# MDL Engineering Services

**Date:** October 24, 2024

**Re:** 3rd Party Foundation Inspection  
2065 Chalybeate Springs Road  
Fuquay Varina, NC 27526  
MDL Project No. SD20338

Crawl Space Foundation

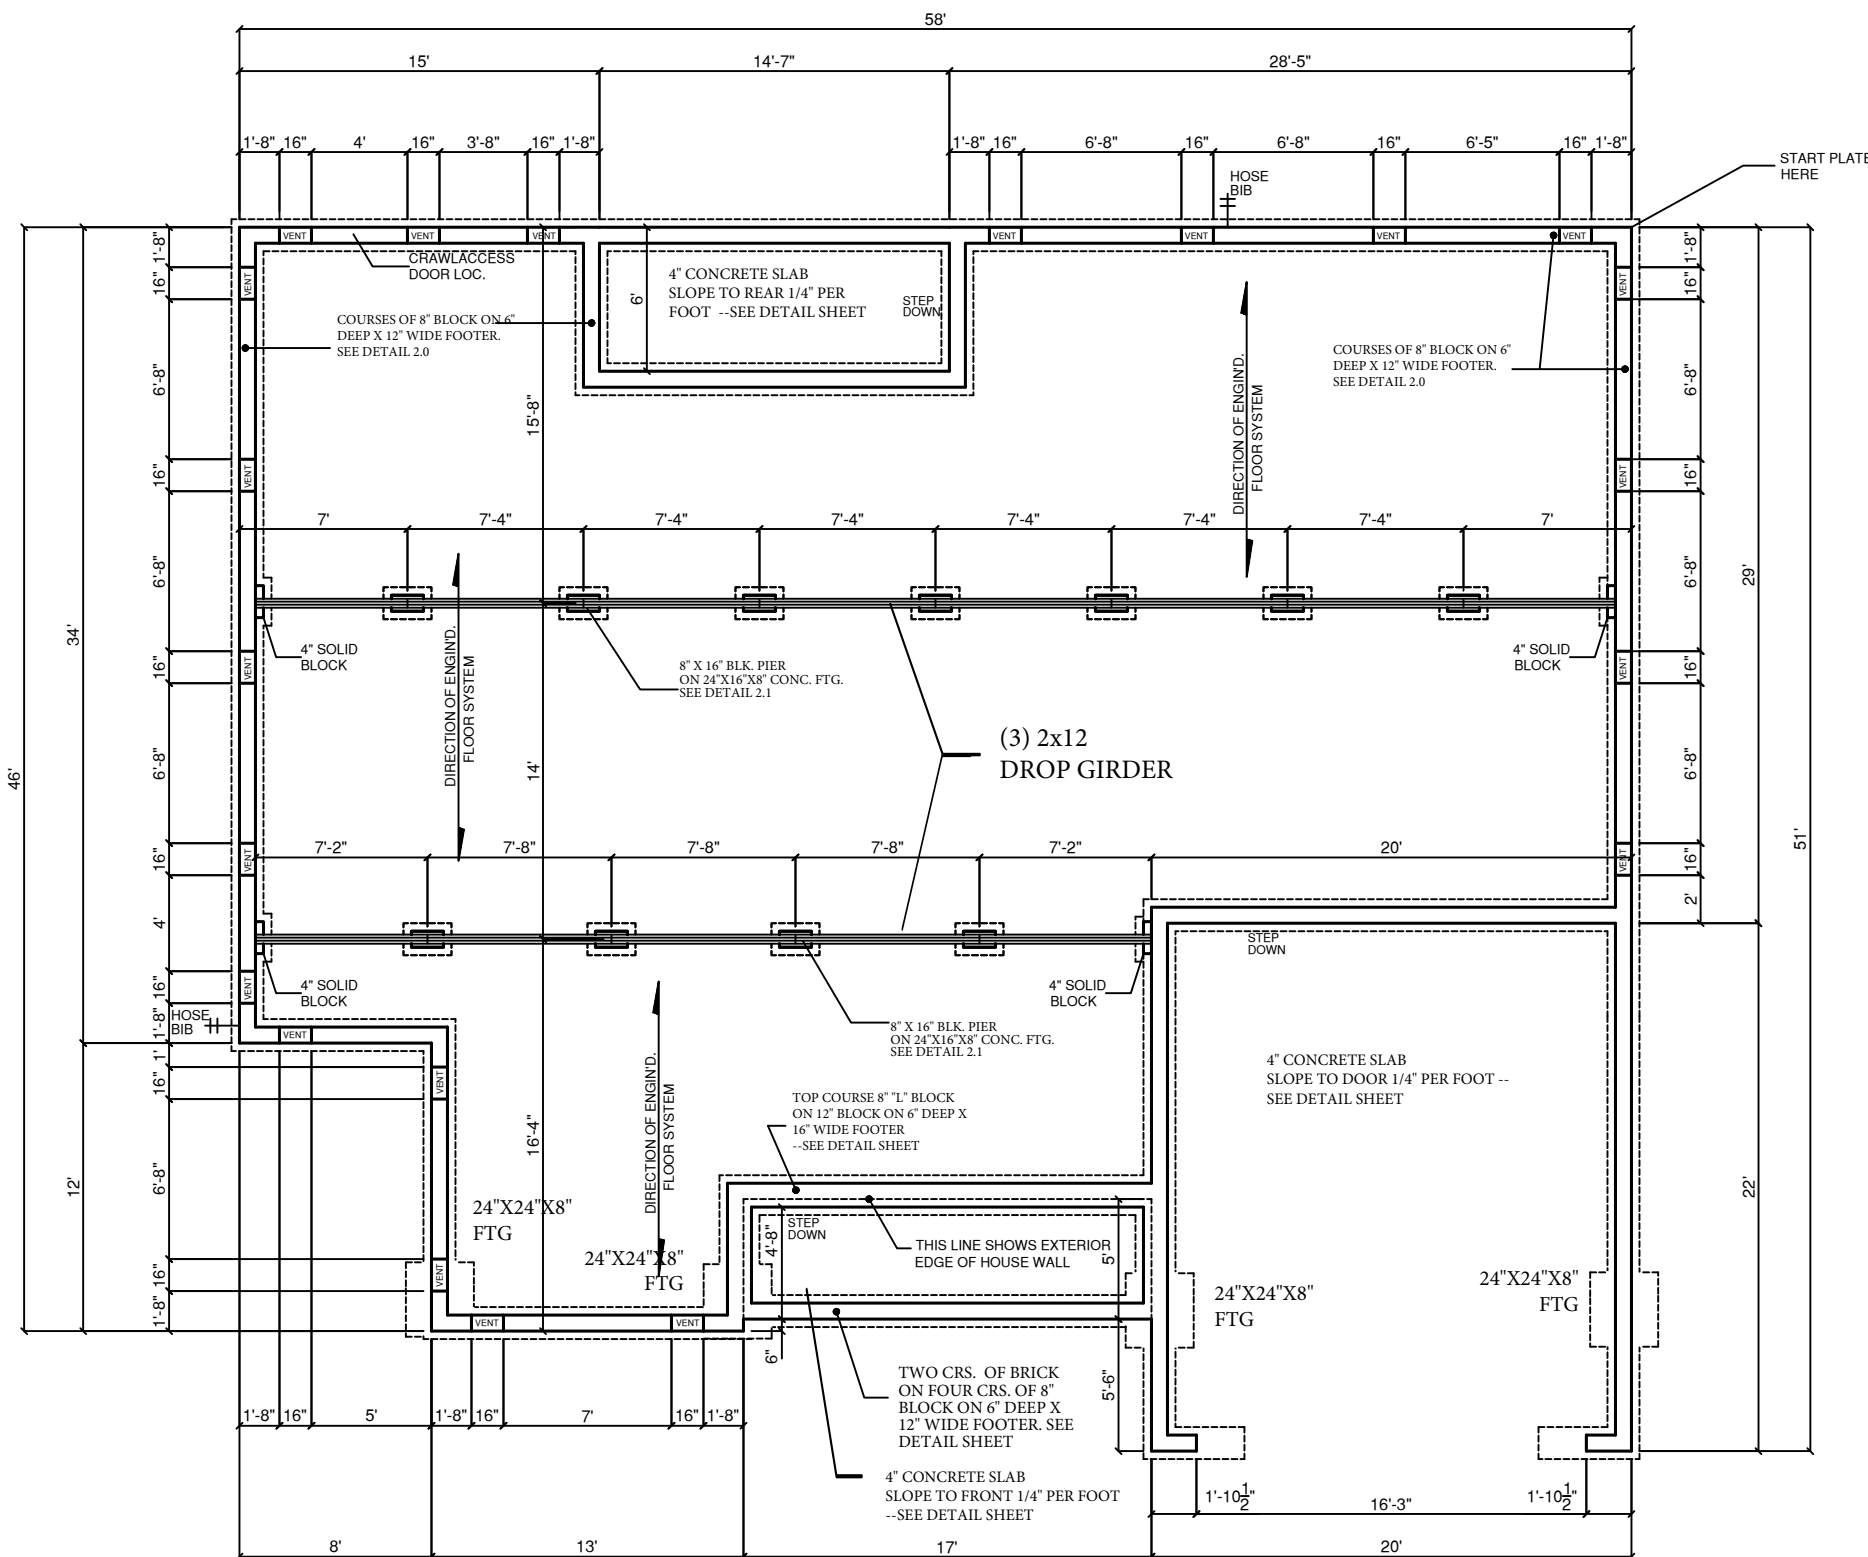
1. Footing projections all at or greater than 2".
2. Block corners installed with interlocking matches between courses.
3. Vents all placed as specified.
4. Crawl Access door installed, although on left side as opposed to the rear of the home.
5. Pier blocks were solid fill. Piers built as 16"x16", although 8"x16" was detailed. This is acceptable.

**CMU PIER/FTG
DROP GIRDER
DETAIL 2.1
N.T.S.**

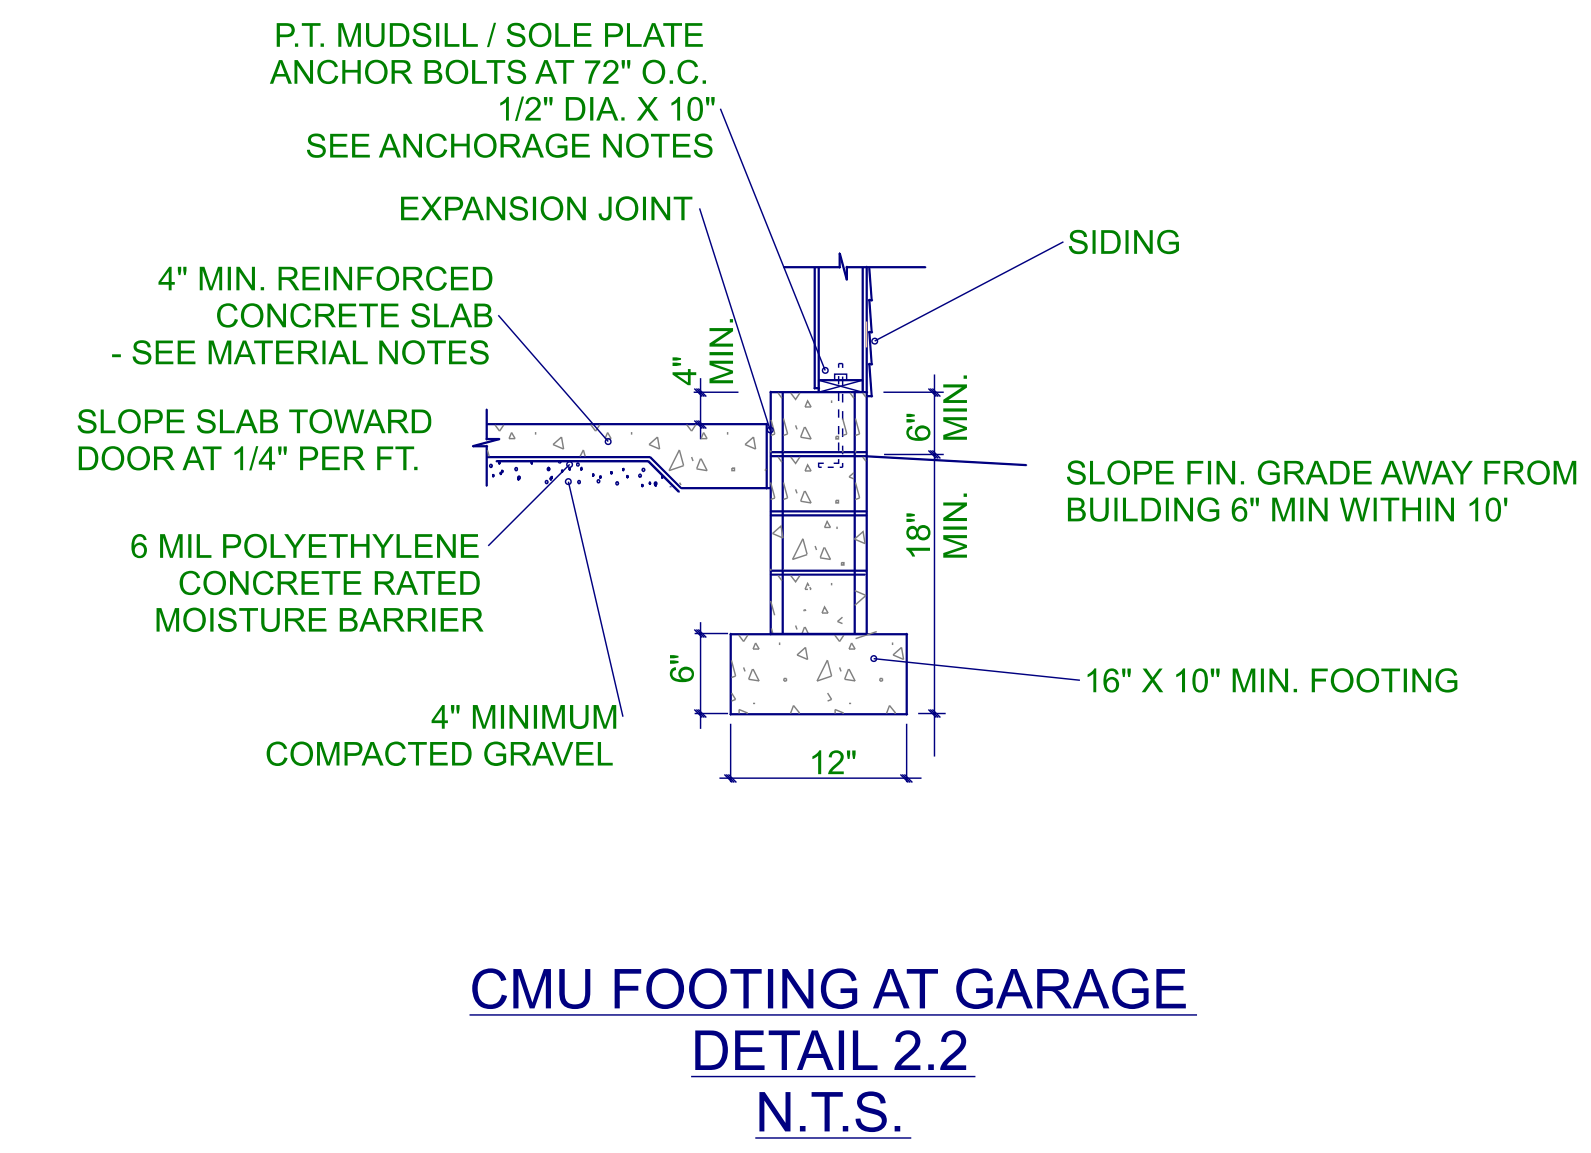
6. 4" solid block required at ends of Drop Girders built as 8"x16" solid fill. This is acceptable.
7. 2 Course bricks (plus top ledge) placed as required. Allows for enough slope with base and I Joist Install.
8. J Bolts placed as required by code.
